From: [REDACTED]
To: [M20 Junction 10A](#)
Subject: M20 J10a
Date: 27 February 2017 19:49:09

RIGHTS OF WAY AND ACCESS PLANS
REGULATION 5(2)(k) & 5(2)(o)
SHEET 3 OF 4

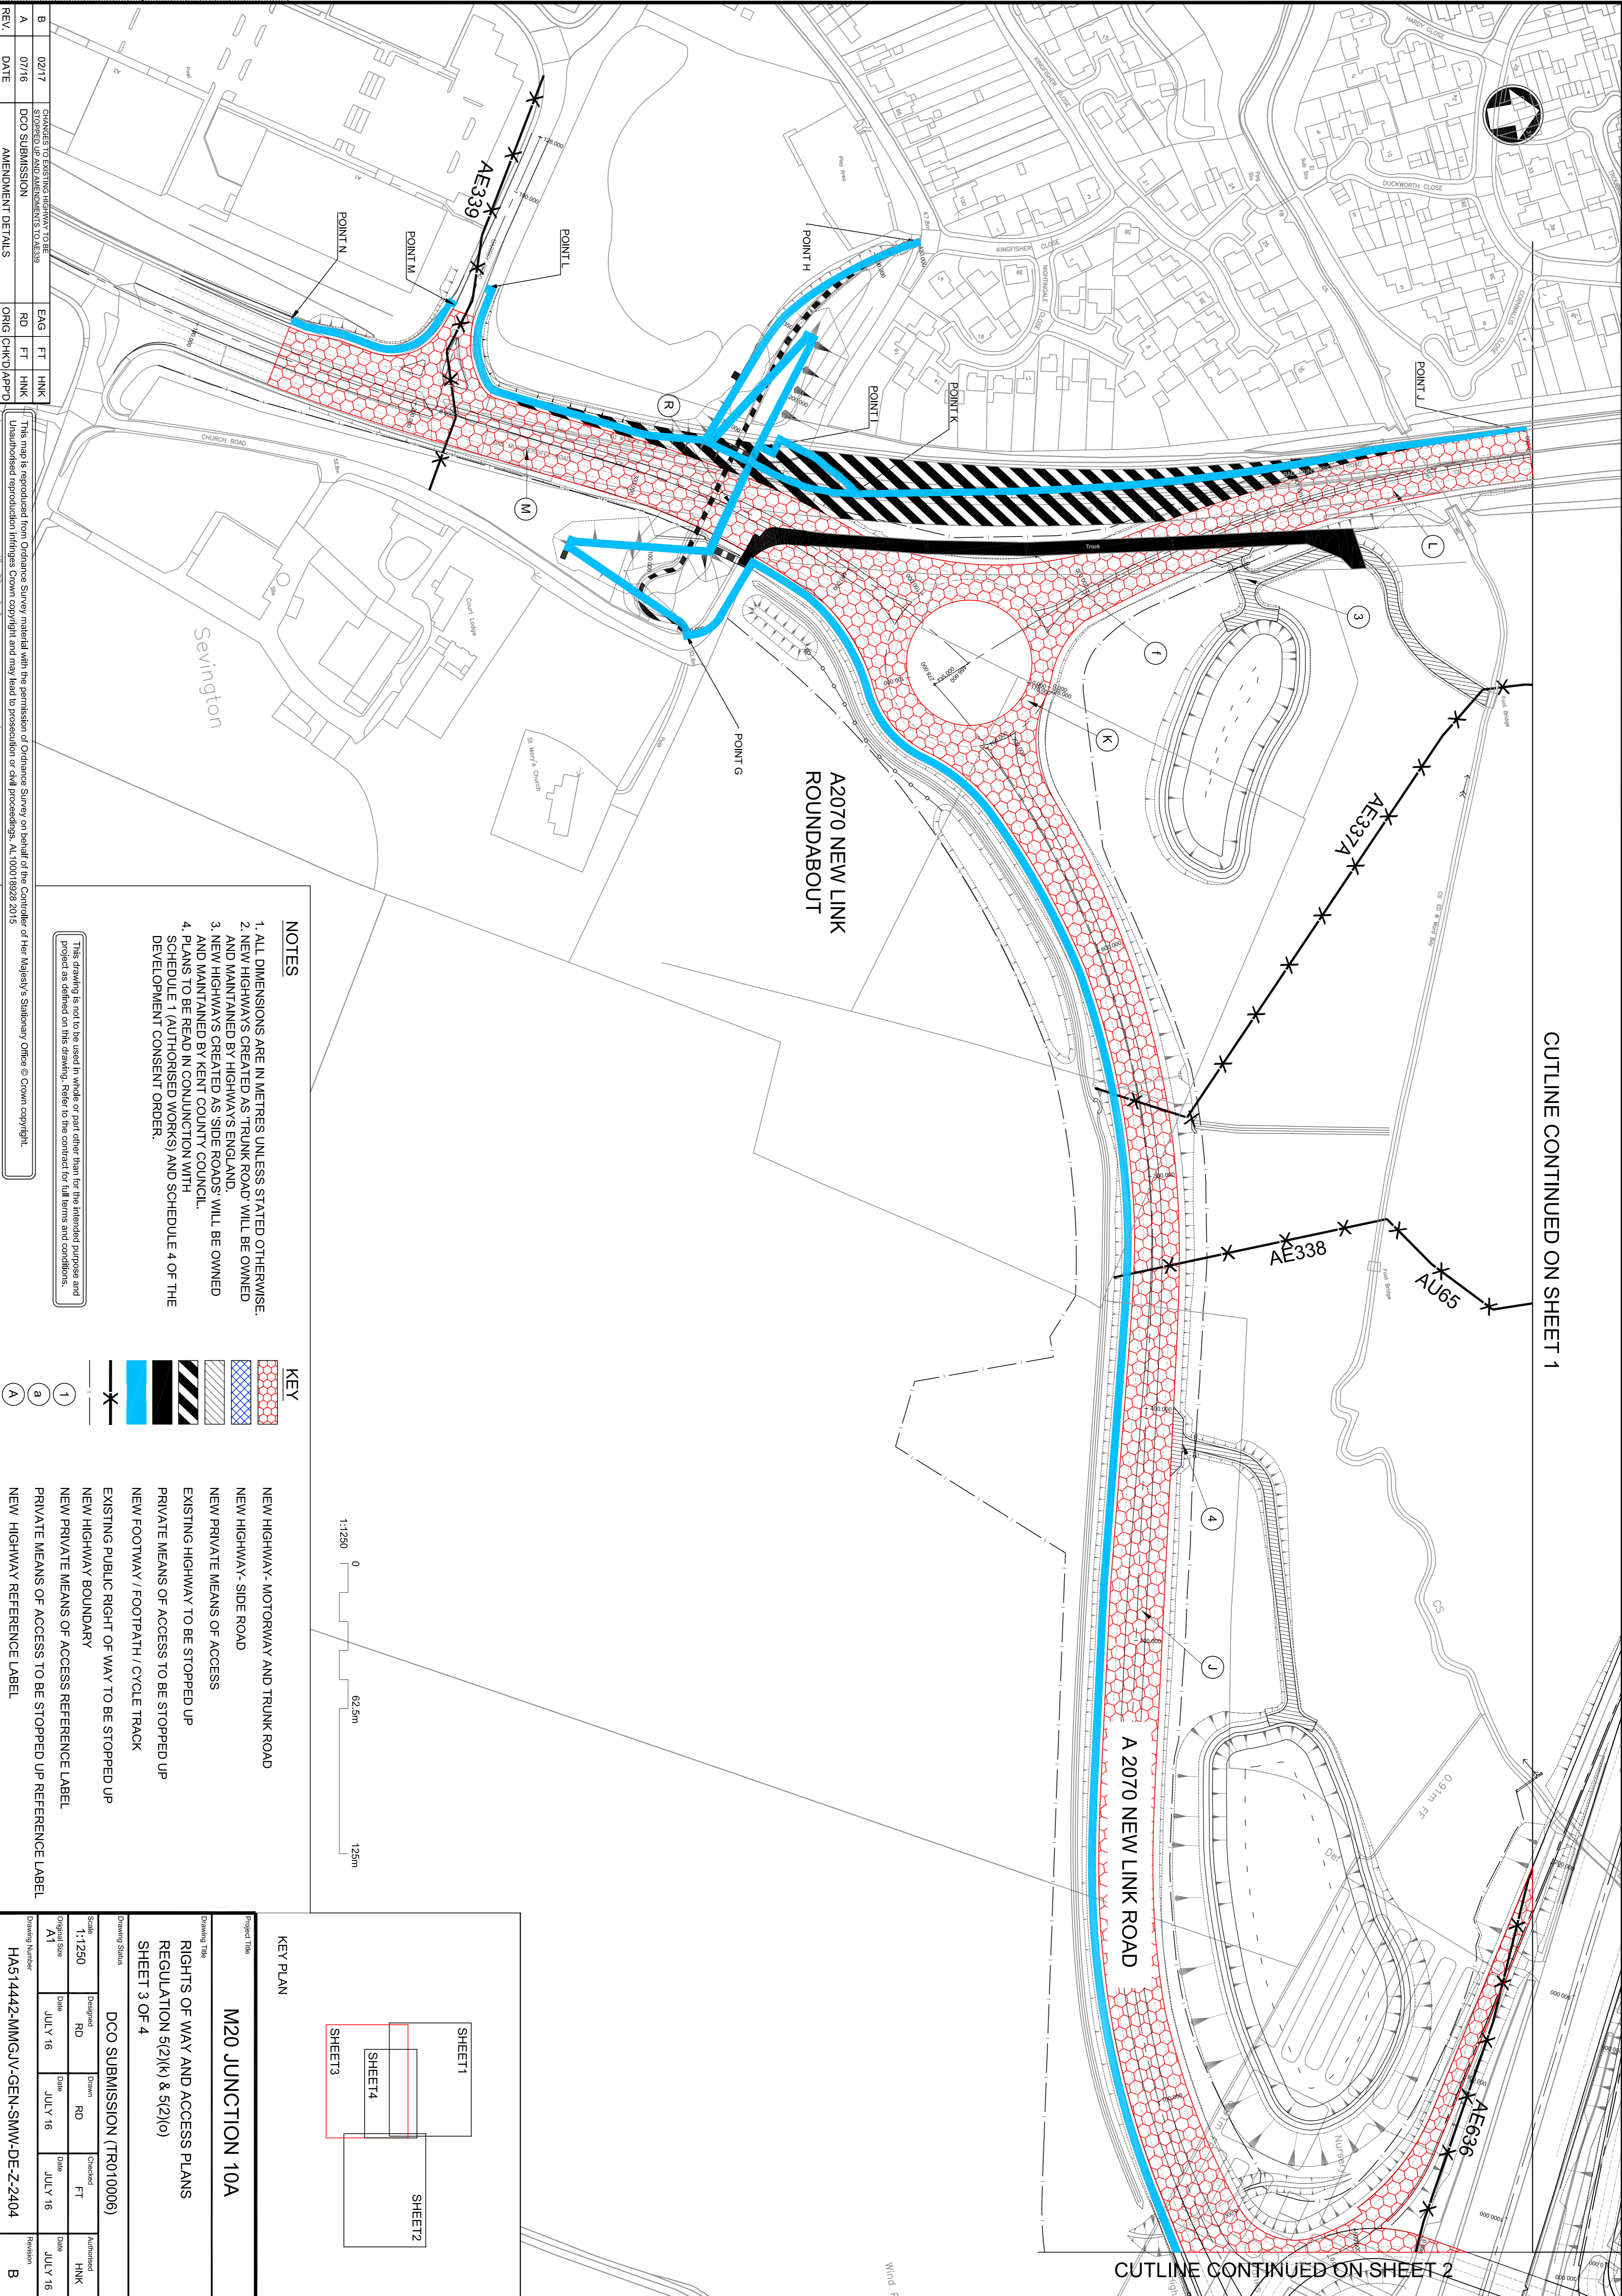
At the end I made a comment that although the bridge now has equestrian access, the bridge exit is between the M20 & A20, which causes the problem for pedestrians, cyclists & equestrians to cross the A20 if they were to continue to the Wye Downs and surely this is a Health & Safety issue.
